File No. : CMDA/PP/NHRB/S/0572/2020

Date : 11 November, 2020

Sub: CMDA-Area plans Unit - 'B' Channel (South) – Planning Permission Application for the proposed construction of Stilt floor + 5 floors with 18.25m height Residential Building with 10 dwelling units at Station Road (Urapakkam Flyover Service Road) S.No.142A/1A1 of Kilambakkam Village within the limit of Kattankulathur Panchayat Union - Remittance of DC & Other charges – DC advice Sent - Reg

SECTION - AA

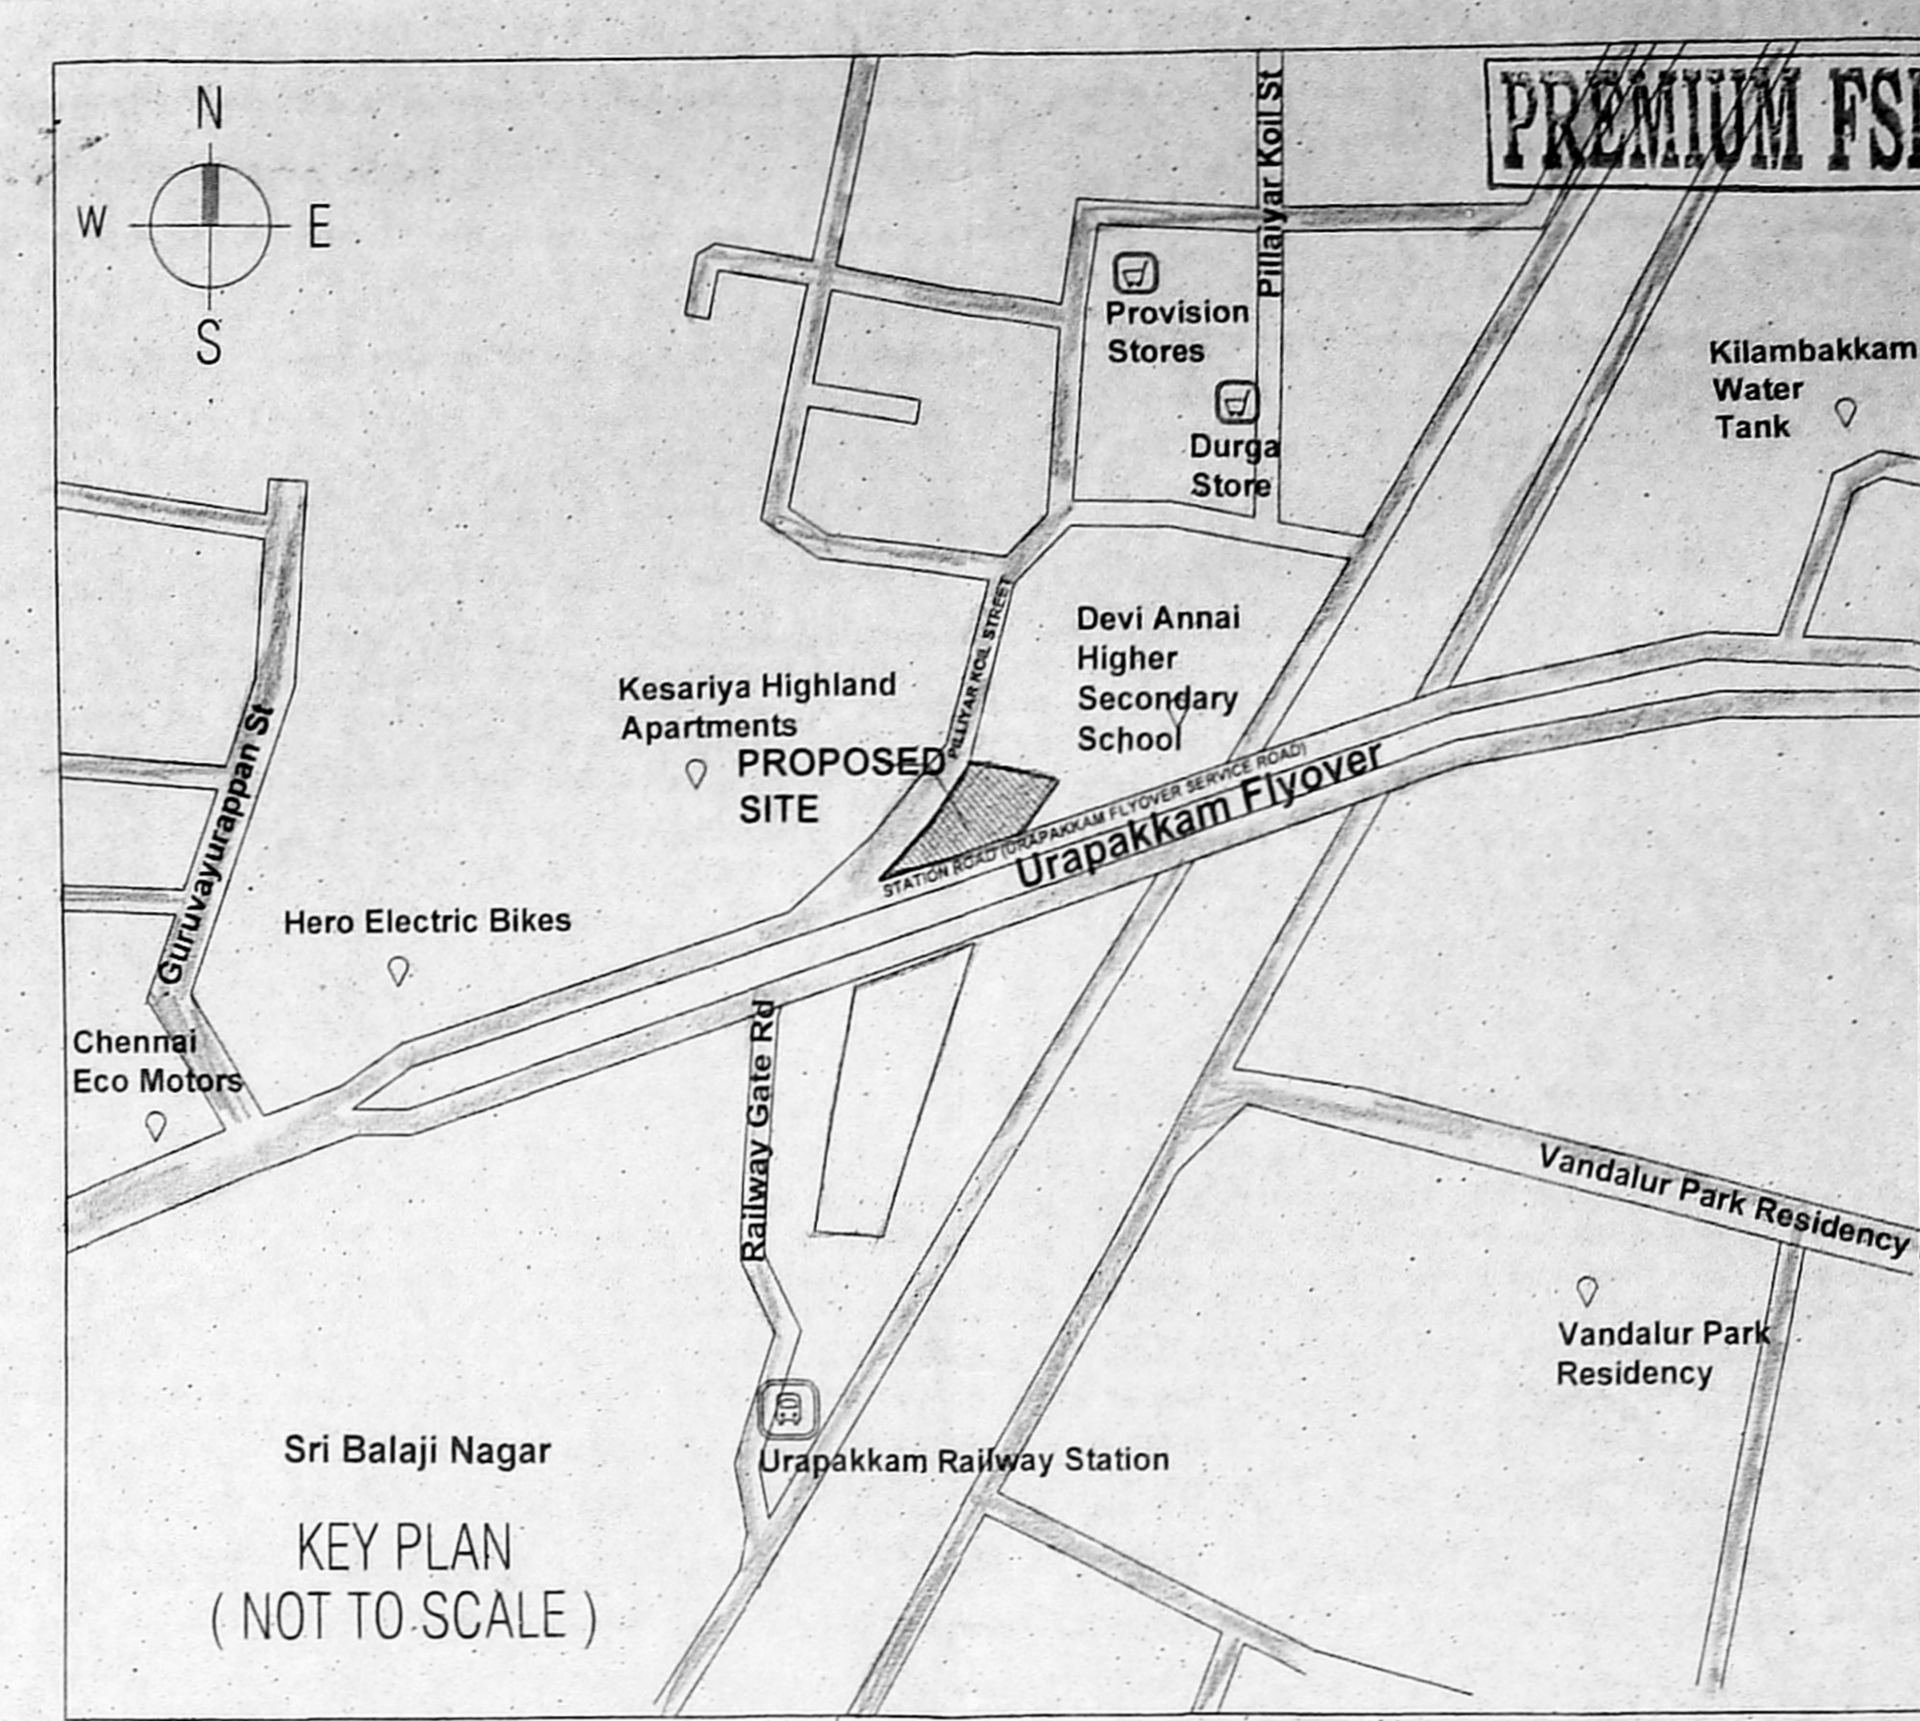
- Silt floor height from beam bottom to be shown in the section and elevation.
- Applicant should be signed in the all pages of application forms.
- Colour notation as per TNCDDBR to be shown.

SITE CUM STILT FLOOR PLAN

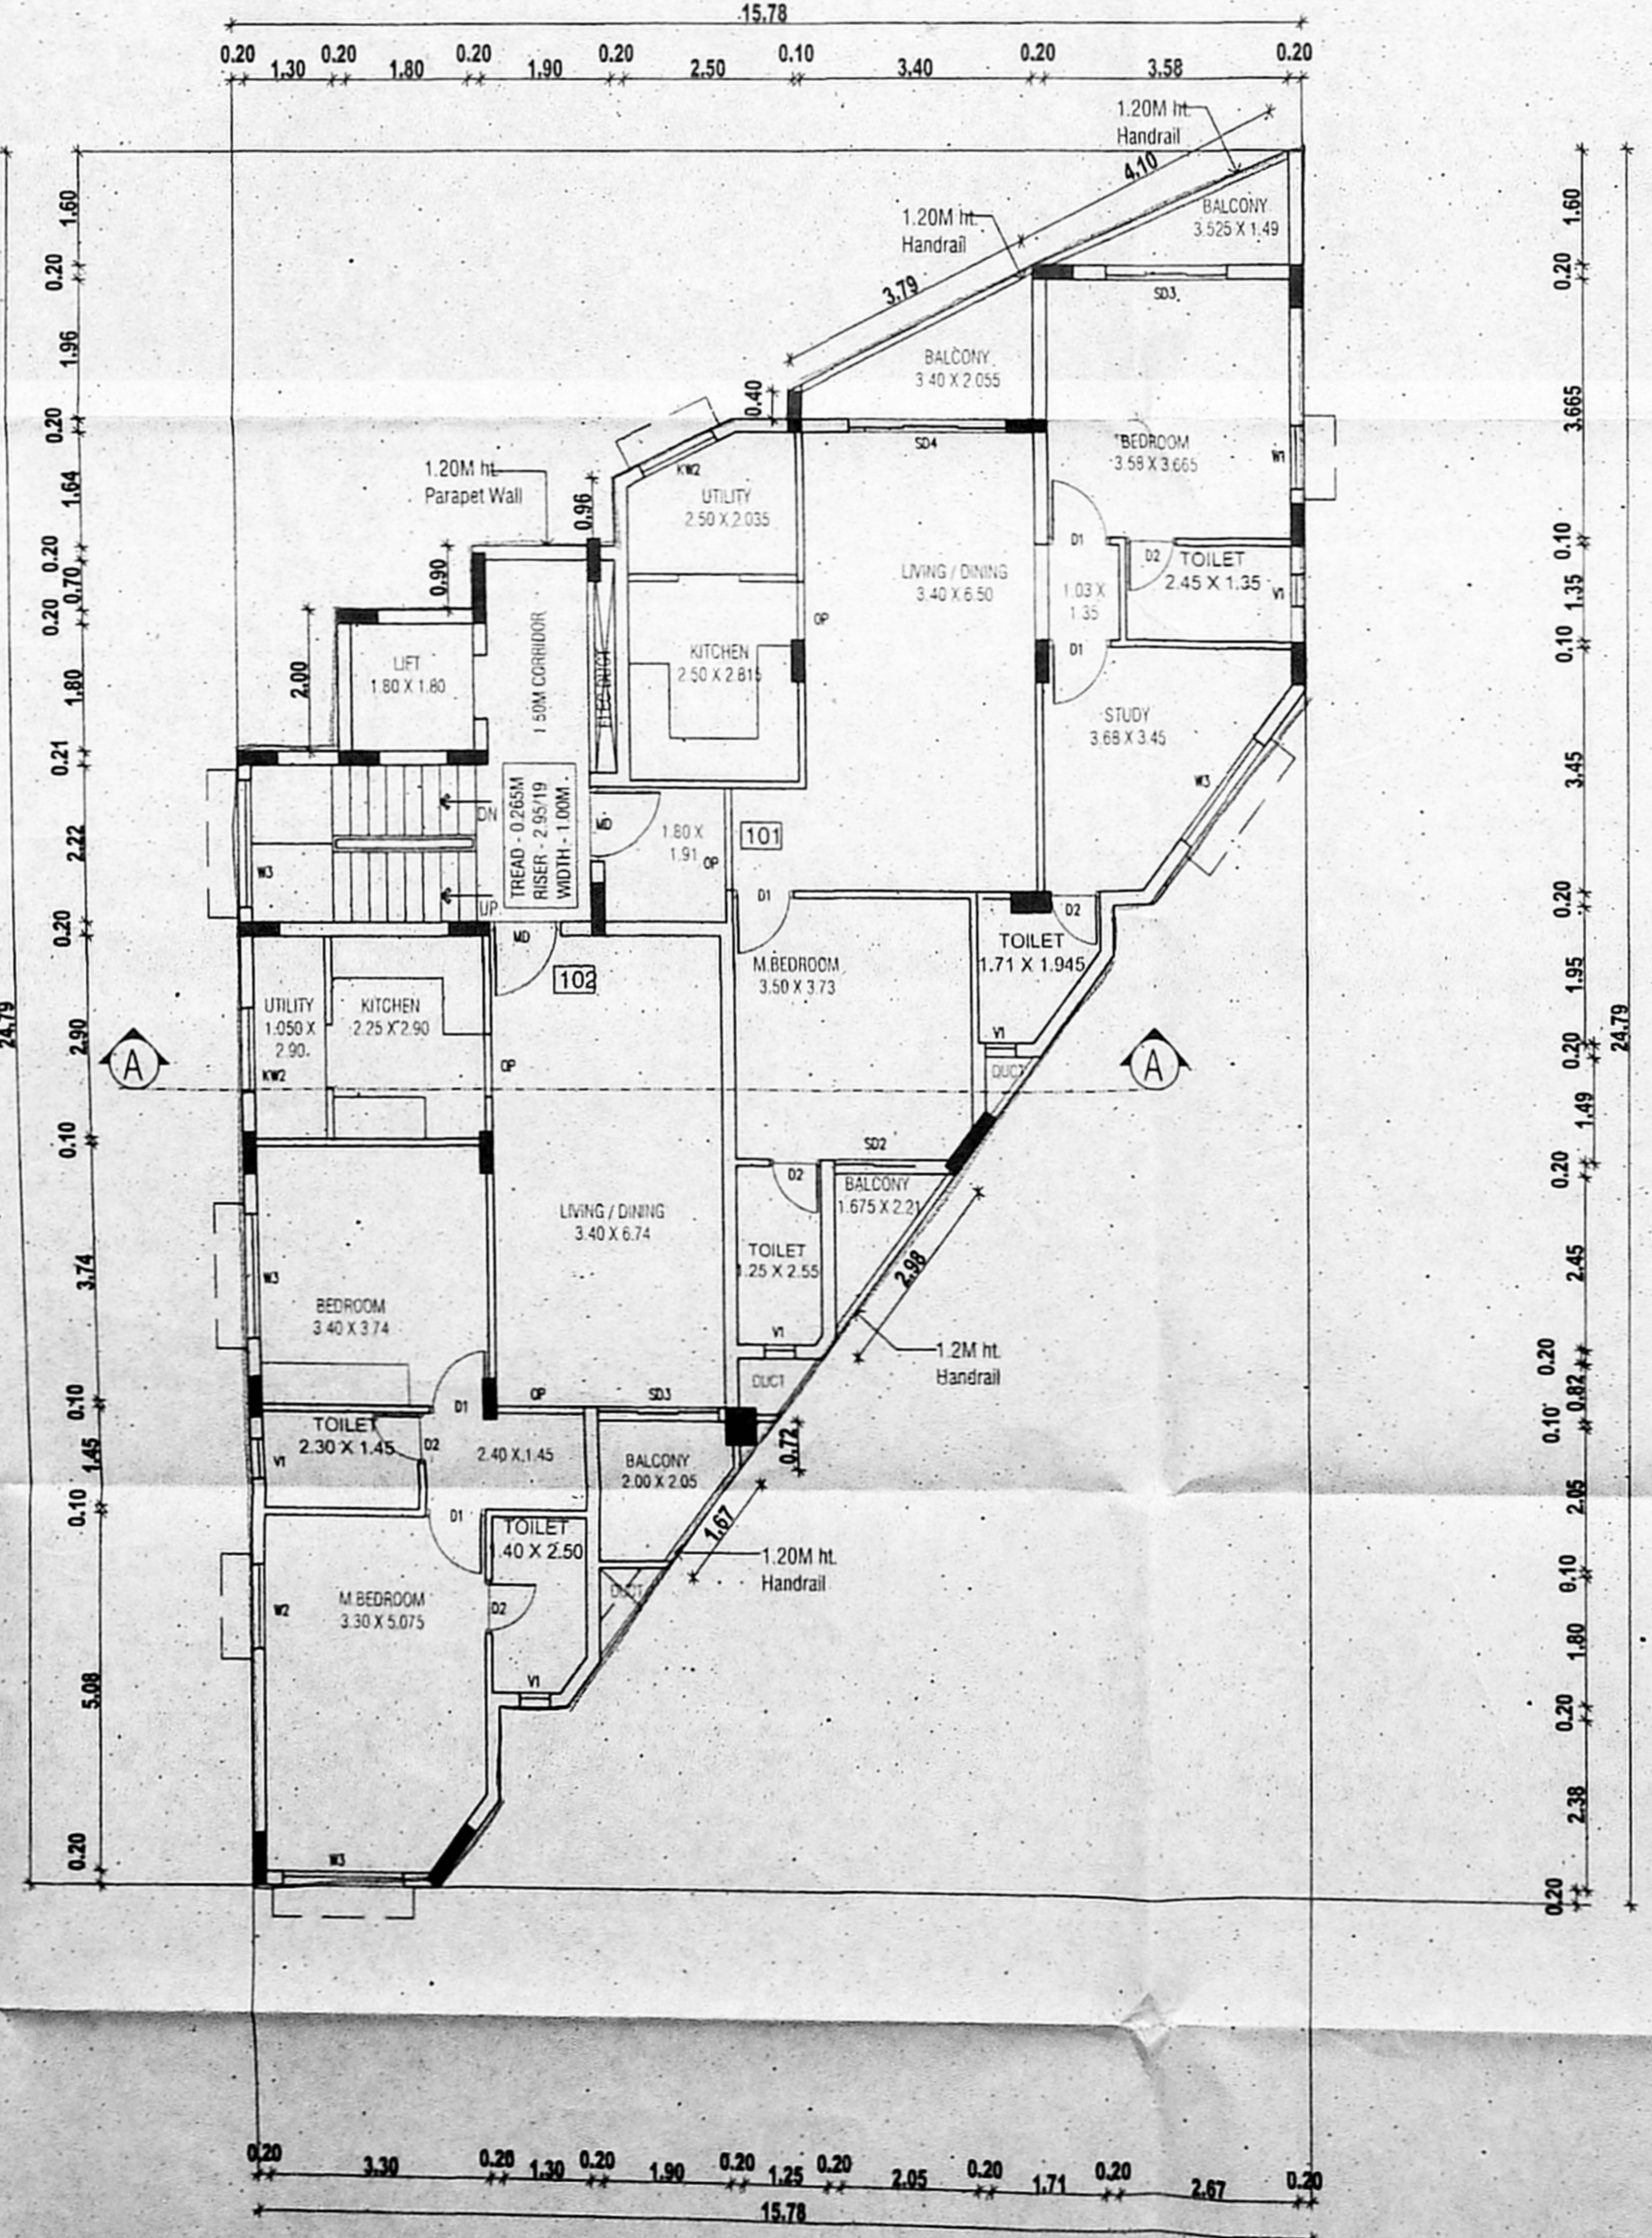
- Site plan showing dimension of site both as per Approved subdivision / Approved Regularization and as per site condition, distinguishing the difference are by hatching and showing setback from minimum dimension line was not furnished. The different in land portion (Hatched portion) to be shown opposite to road.

- Car parking to be rearranged to accommodate required parking.
- Rainwater harvesting provisions to be shown as per TNCDDBR.
- Drawing to be furnished with a scale of 1:100.

- Correct road name to be mentioned in the site plan and drawing title.
- Road width as per inspection observation to be shown in the site plan.
- Area statement, drawing title and subtitle needs correction.
